City of Albuquerque

RE: DRAINAGE PLAN FOR MEADOWS PARK (G12-D19B)
RECEIVED JULY 14, 1995.

I have reviewed the referenced plan dated June 28, 1995 and forward the following comments:

MEADOWS ON THE RIO GRANDE PARK
GRADING & DRAINAGE PLAN

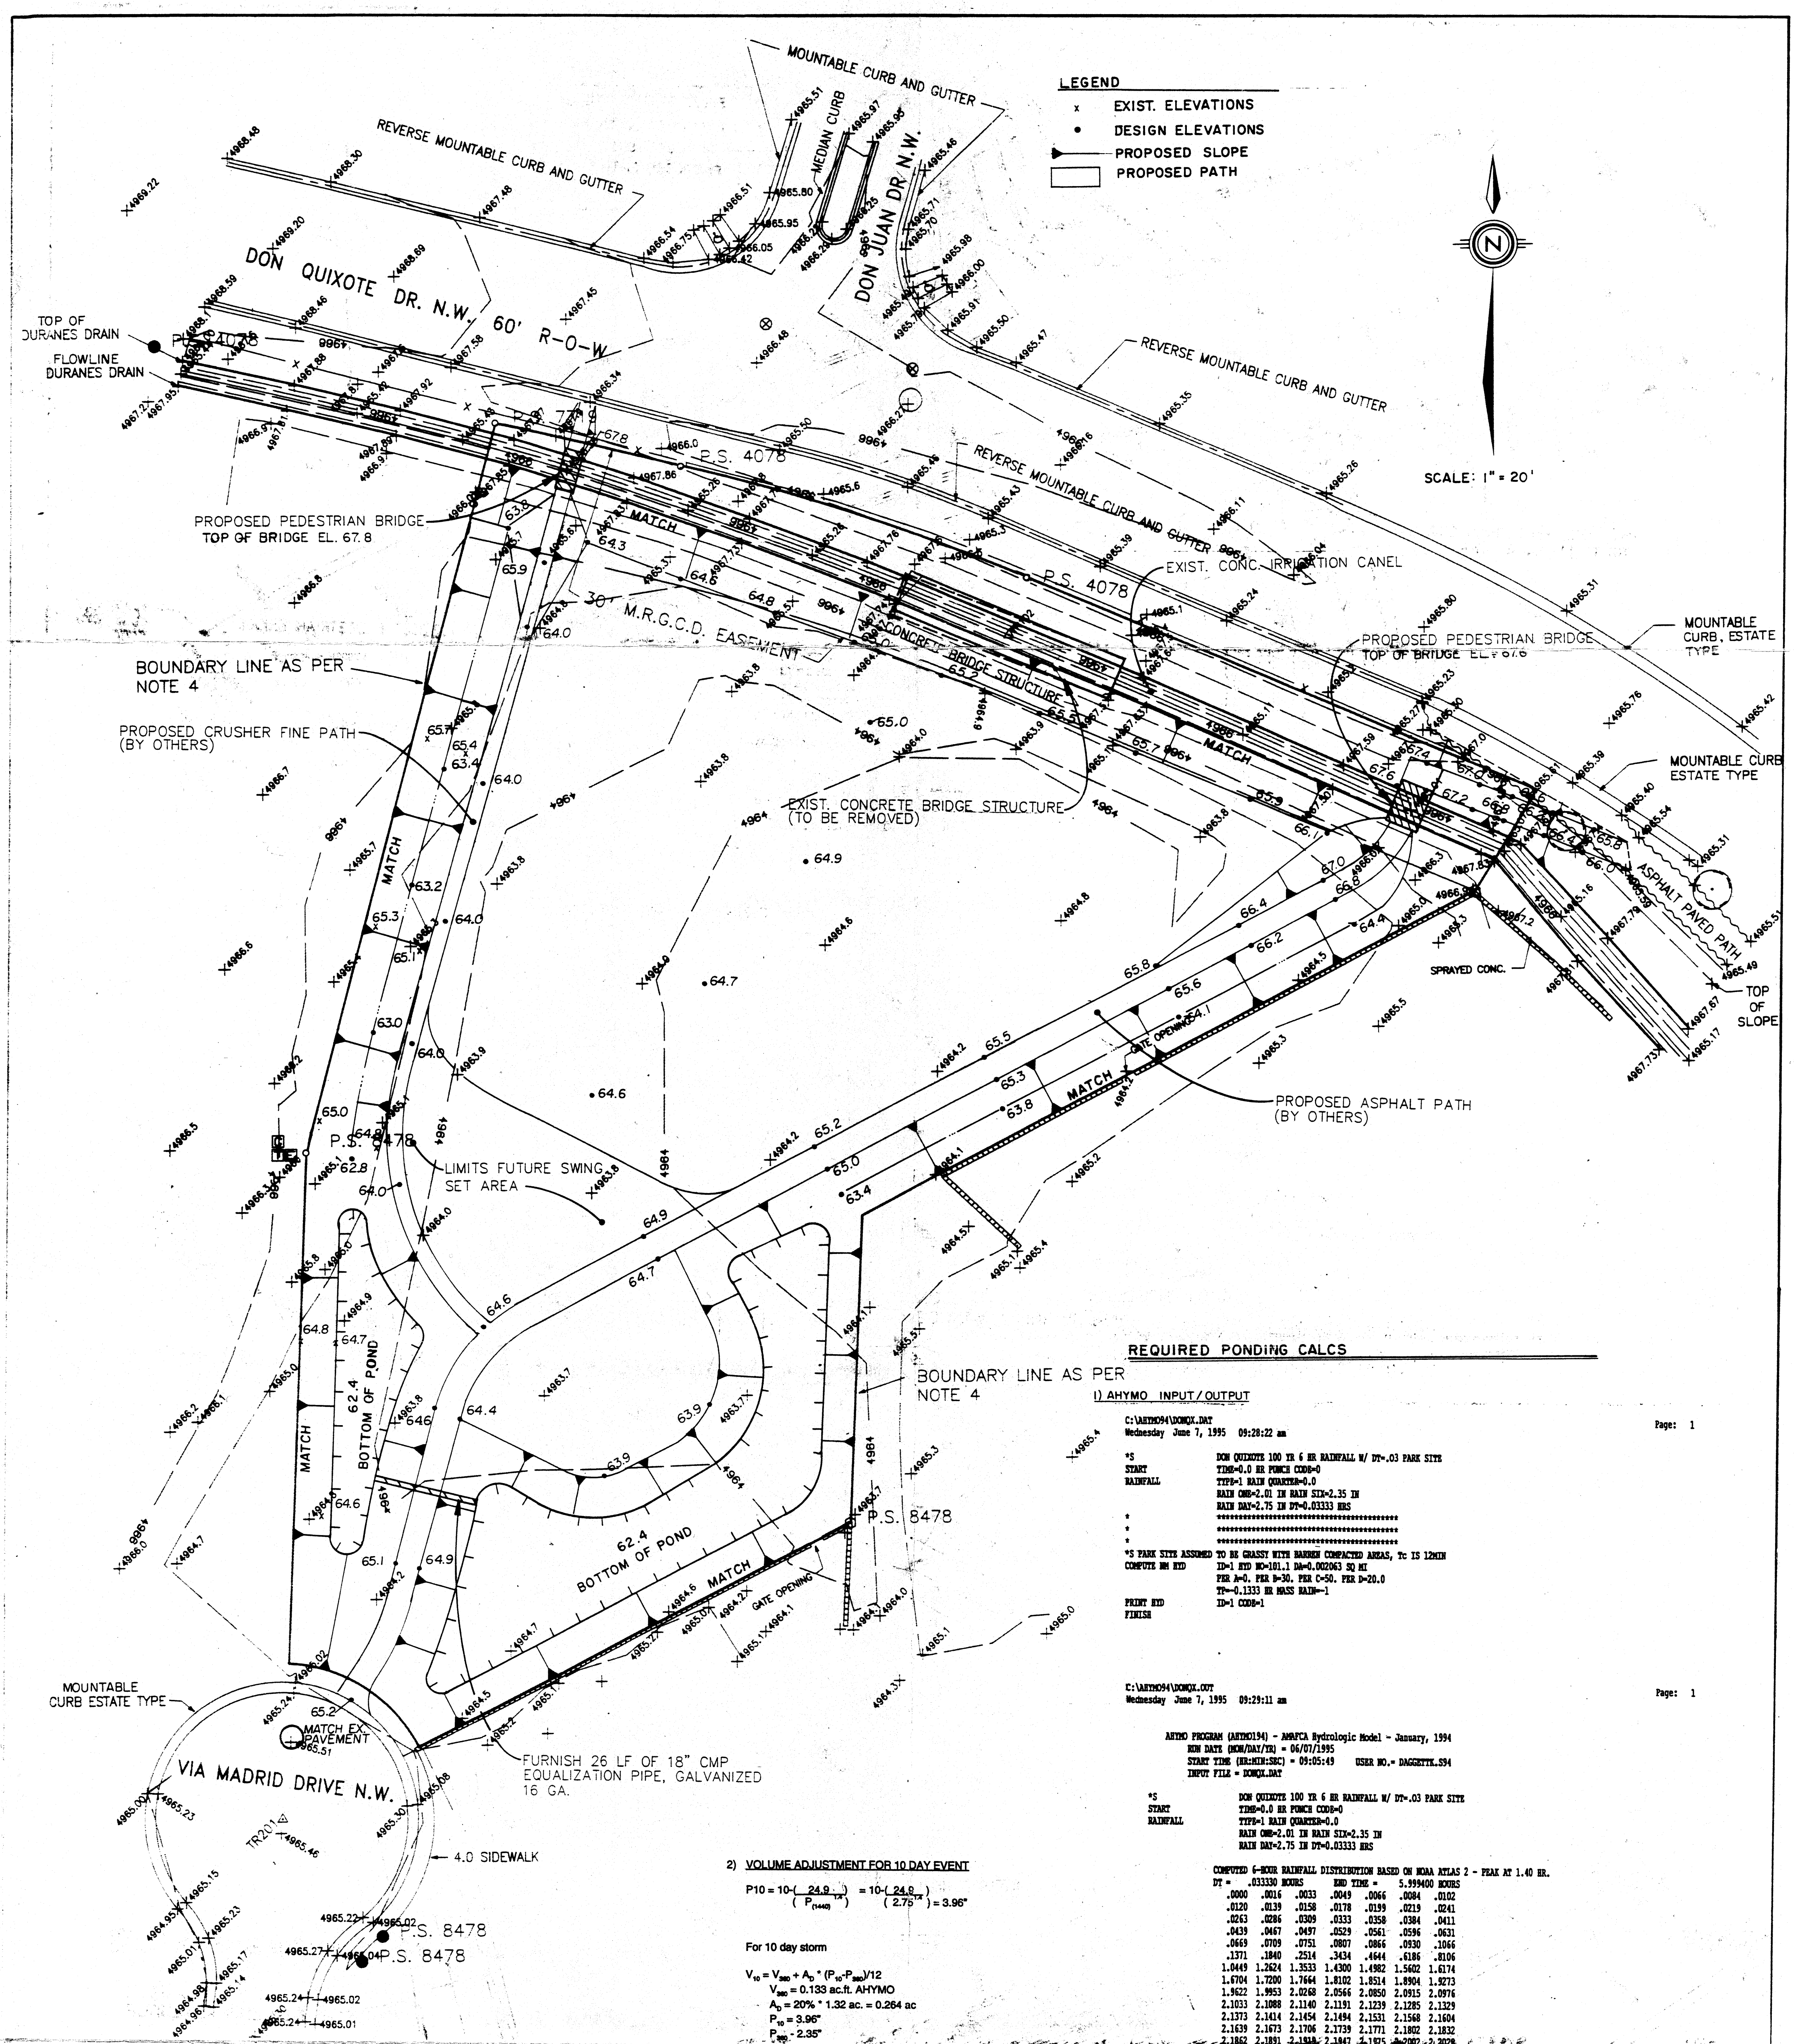
The park is designed using retention ponds. Retention ponds are contrary to City Drainage Ordinance. It appears there are no structures being constructed or large scale grading, therefore, keep the historic grades and slopes. If grading is necessary use a flat grading concept.

The City Drainage Ordinance does not give us a choice on the use of retention ponds. Retention ponds cannot be used in this project. You can use a flat grading concept. The entire site would be at the same elevation. Also, the off-site flows must be accepted if there are any.

This park is an infill project in the Thomas Village area. Thomas Village & the Meadows have been developed based on retention. Grading follows Parks & Rec. direction to create a flat (1%) playing field which is dry after a 100 year event. I trust you will approve the plan on this basis. *KM*
